June 6th, 2023

RE: NuVue 6th St. & Cutler Ave.
2300 6th St. NW
Traffic Circulation Layout

Thank you for the comments provided on the Traffic Circulation Plan for NuVue 6th and Cutler project on April 19th, 2023. Note that the site plan layout has been updated to meet the City of Albuquerque's zoning requirements and that your previous comments were taken into consideration during the design process. Below in [blue](#) are SEH's responses to comments 1-34 for Building Permit approval.

SHEET NO. 100

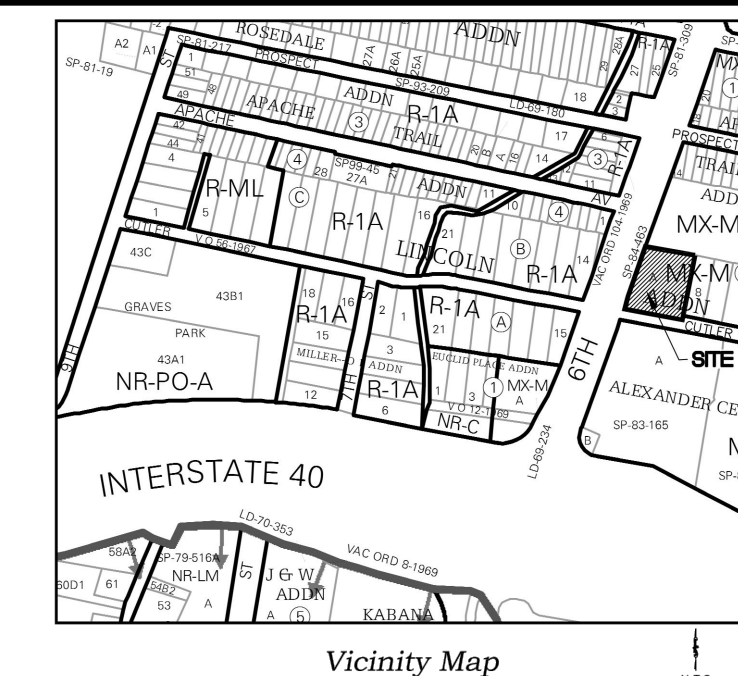
3. Identify the right of way width, medians, curb cuts, and street widths on 6th St. and on Cutler Ave. [Response: Street widths, median dimensions and right of ways have been added to the plans.](#)

6. The minimum distance from the site access off Cutler to the intersection of Cutler and 6th St. should be 75 ft. Please show this dimension on the site plan. [Response: The dimension has been added to the site plan.](#)

8. The ADA accessible spaces must include an access aisle. Van accessible aisles should be 8ft wide; all others should be 5ft wide. **Response:** An access aisle is being provided on plans.

13. The pavement marking "MC" should be shown in the opposite direction for Motorcycles entering the parking space. **Response:** "MC" pavement marking note has been added to the plans along with a side note.

19. Per the IDO, a 6 ft. wide ADA accessible pedestrian pathway is required from the public sidewalk to the building entrances. Please clearly show this pathway and provide details. **Response:** A 6 ft accessible pedestrian pathway has been provided from the west side of the development.

28. Show the clear sight triangle on both site accesses and add the following note to the plan:
“Landscaping and signage will not interfere with clear sight requirements. Therefore, signs, walls, trees, and shrubbery between 3 and 8 feet tall (as measured from the gutter pan) will not be acceptable in the clear sight triangle. **Response:** Clear sight triangles have been added to the plans per COA ordinance 8-2-2-15.
